From: [Cathy Staup](#)
To: [Chace Pedersen](#)
Subject: CU-23-00002 The Outpost
Date: Monday, November 20, 2023 2:05:39 PM

I wish to comment on the proposed Outpost campground and development located at 13131 Salmon La Sac Rd in Ronald. I ask that a permanent fence or barrier between that property and the private community of Sunshine Estates be installed to prohibit foot and vehicle traffic from traveling on Sandelin Ln or private properties including the Sunshine Estates community lots and lake access which is not available for the public's use. Both Sunshine Estates and the Jackson property have existing access to Salmon La Sac Rd, the Jackson property has approximately 300 feet on SLS Rd which should provide plenty of space for any emergency access needed in addition to the existing access.

**CONCEPTUAL SITE PLAN
MULTIPLE PARCELS**

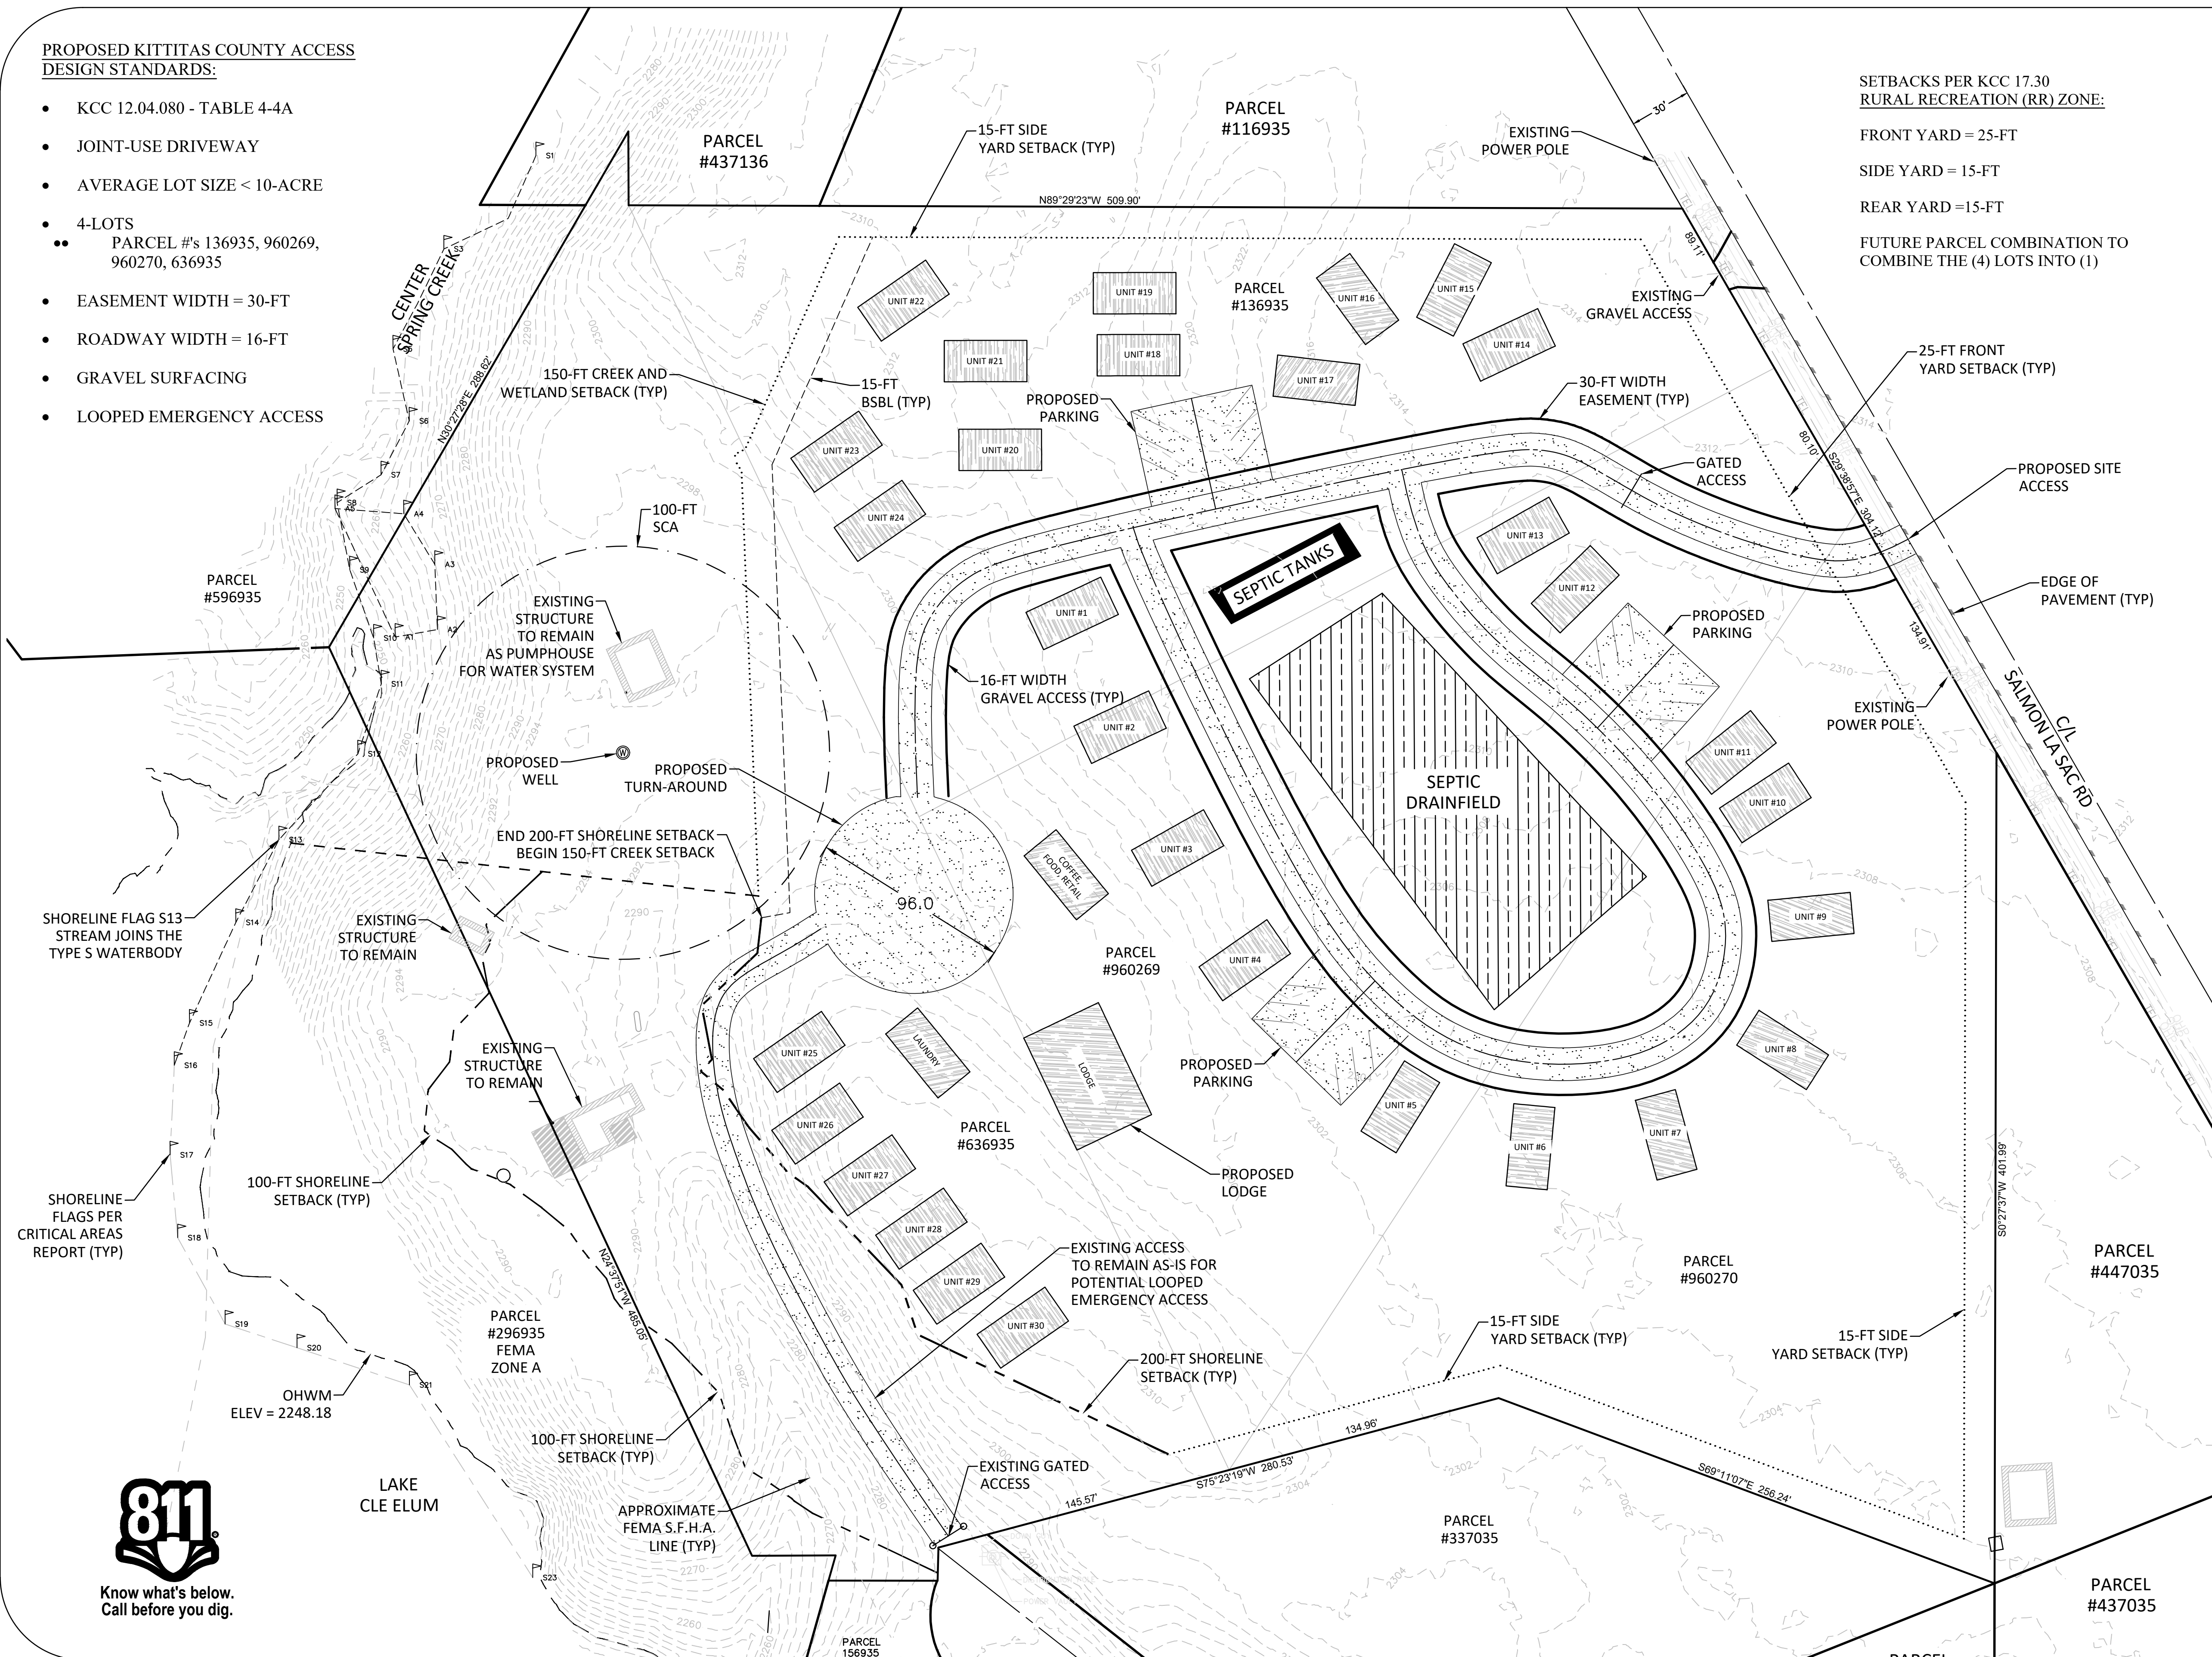
Have any impact studies been done to determine how the proposed water and sewer systems needed for the Outpost will affect the surrounding communities and the water table for existing wells? The Critical Area Impact report done in August 2023 and the Shoreline map use the Ordinary High Water mark as it exists today. Have any studies or reviews been completed to account for the Bureau of Reclamation's pool raising project that will raise the Lake 3 feet?
